M54- M6 Toll Link Road

Planning Inspectorate Reference: TR010054:

**Summary of Natural England's written representations**

3 November 2020

SAFETY, HEALTH AND ENVIRONMENTAL INFORMATION BOX

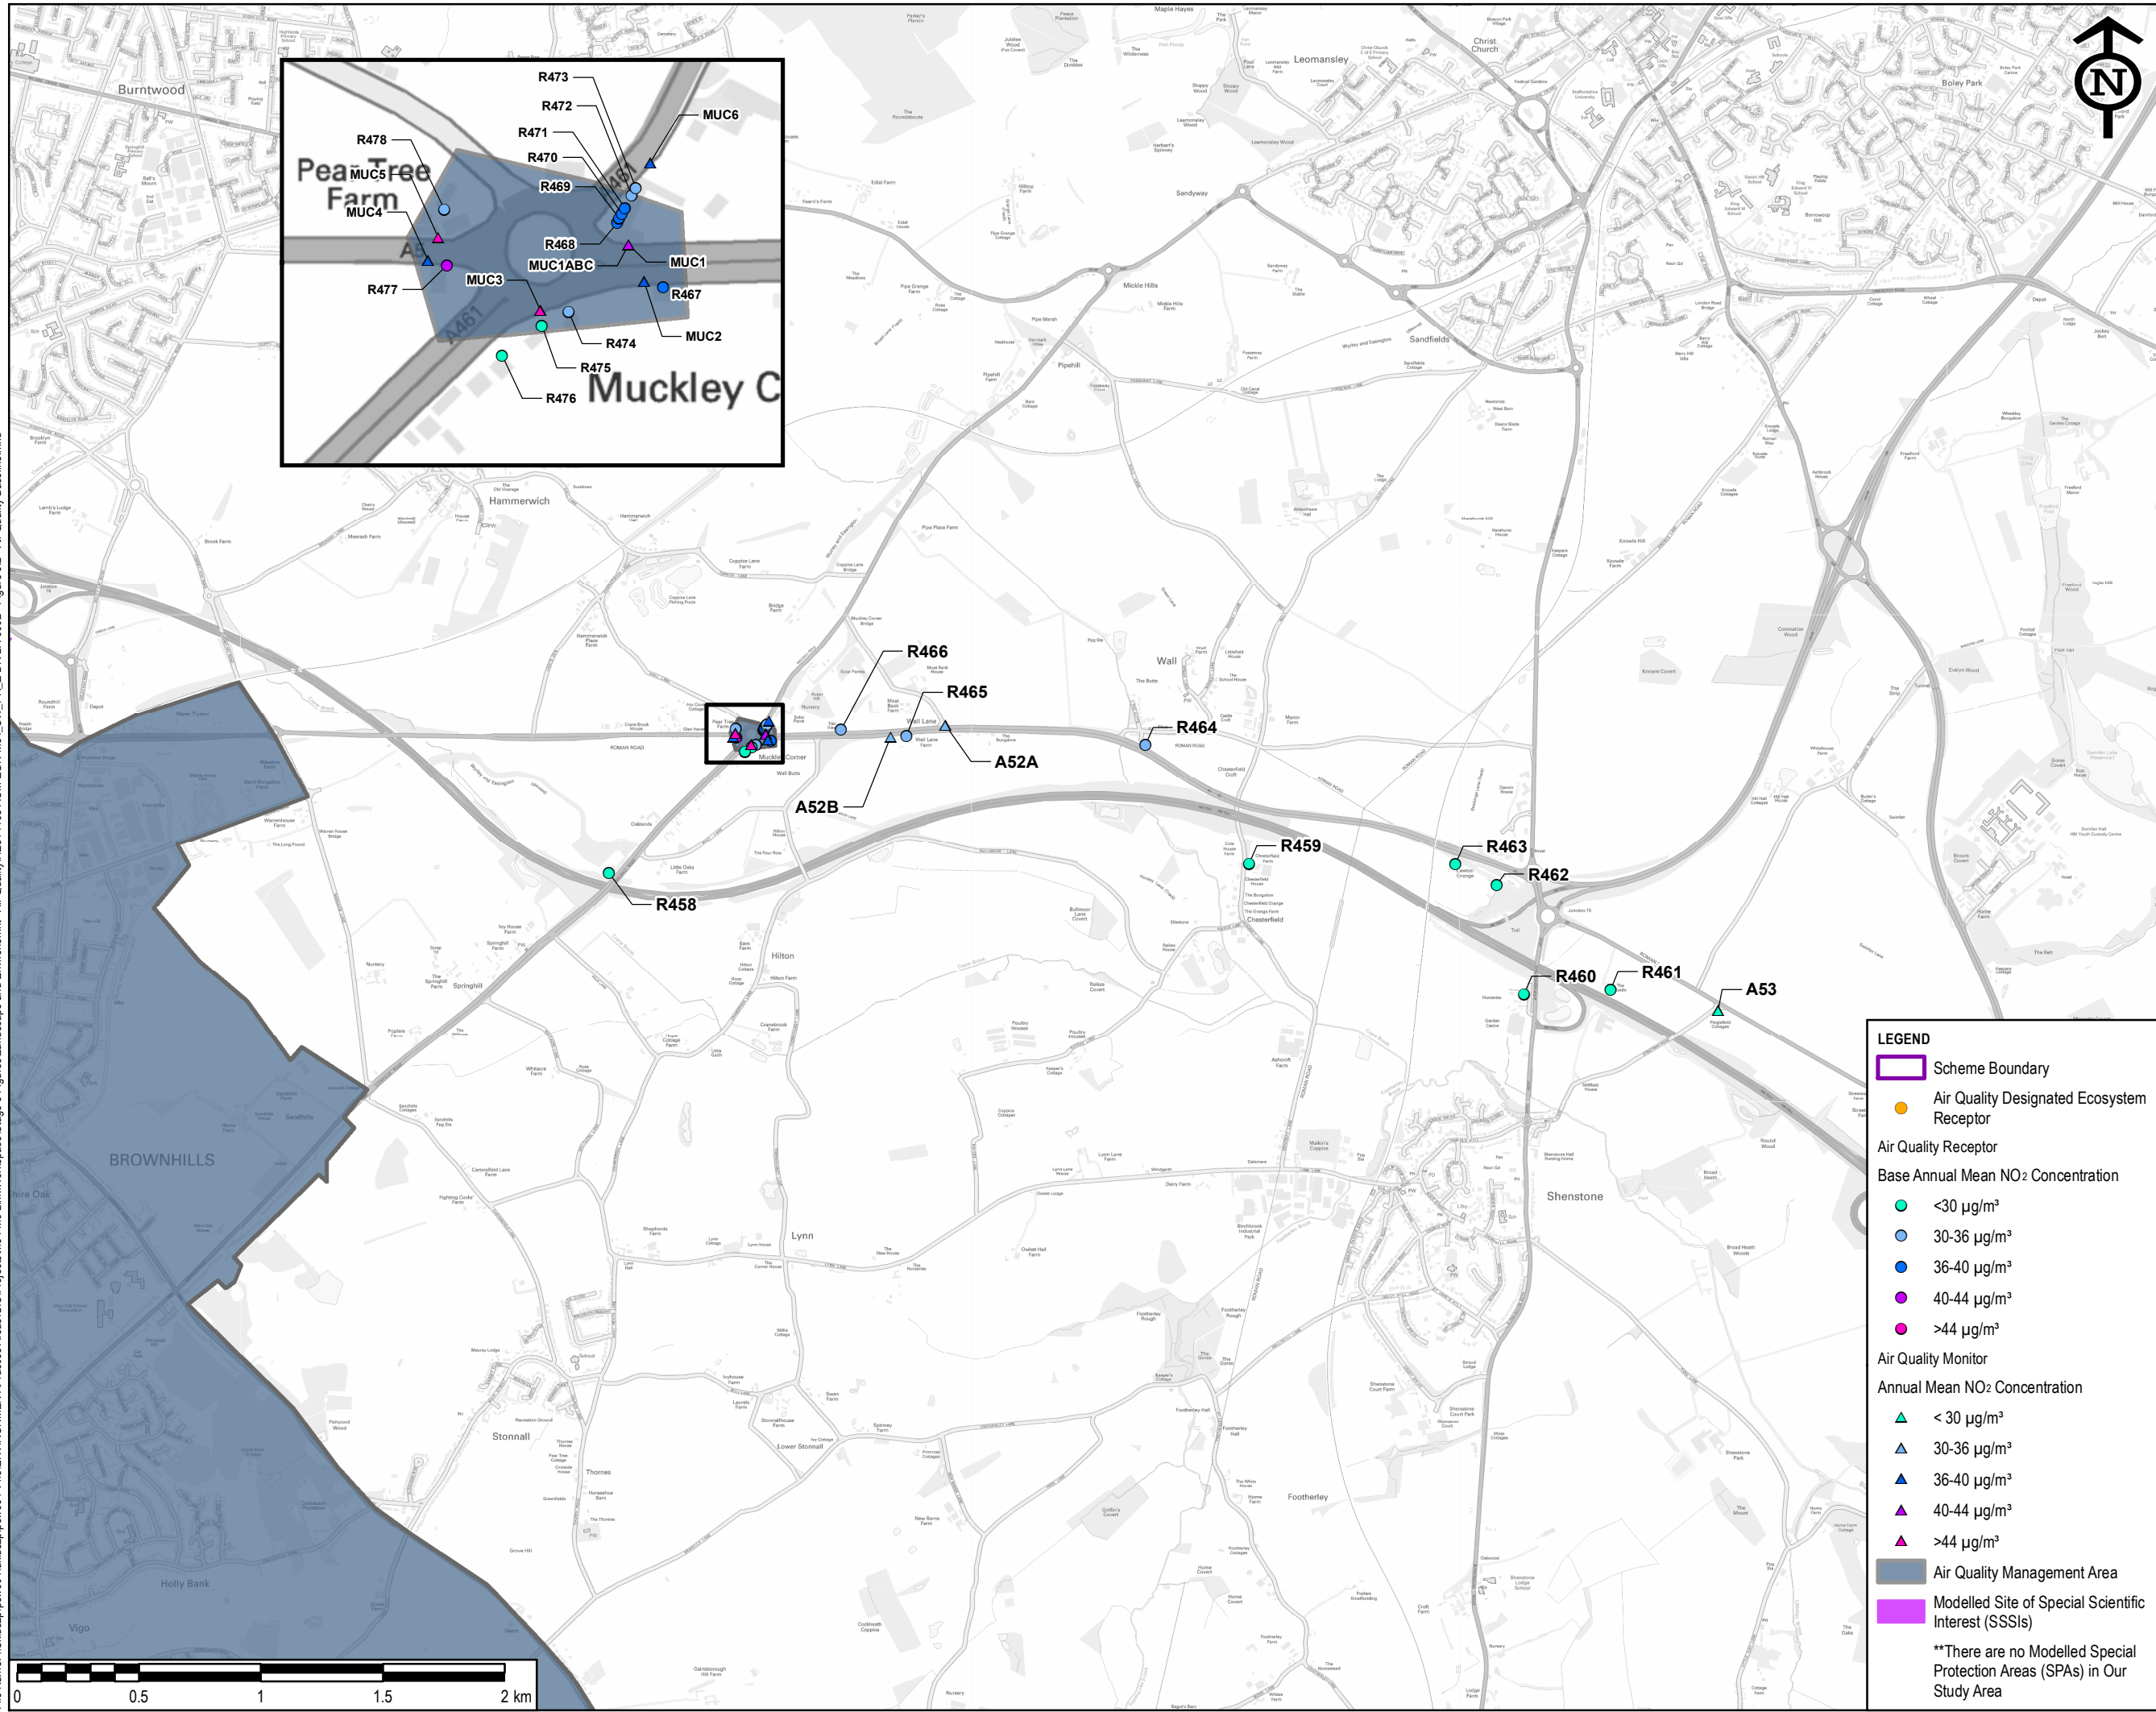
- Confirmation that example sites have been screened out.
      - Indirect impacts require consideration. Cannock Extension Canal SAC is hydrologically linked to Chasewater and Southern Staffordshire Coalfield Heath SSSI, which will be affected by nitrogen deposition.

- 3.2. Nationally designated sites
    - Chasewater and the southern Staffordshire Coalfield Heaths SSSI
    - Stowe Pool and Walkmill Claypit SSSI
      - The scheme would result in increases in NOx and nitrogen deposition at these sites further discussions are required over the assessment and conclusions with regards to potential impacts of these increases (alone and cumulatively) and mitigation.

- Where there is unavoidable loss of ancient woodland the Applicant and Natural England have agreed a ratio of replacement planting and improvement works to Oxden Leasow Wood (also known as Whitgreaves Wood). The detail of the compensation measures requires further discussion.
- Increases in nitrogen deposition on Oxden Leasow Wood and woodland at Brookfield Farm require further discussion on potential impacts on impacts alone and cumulatively.
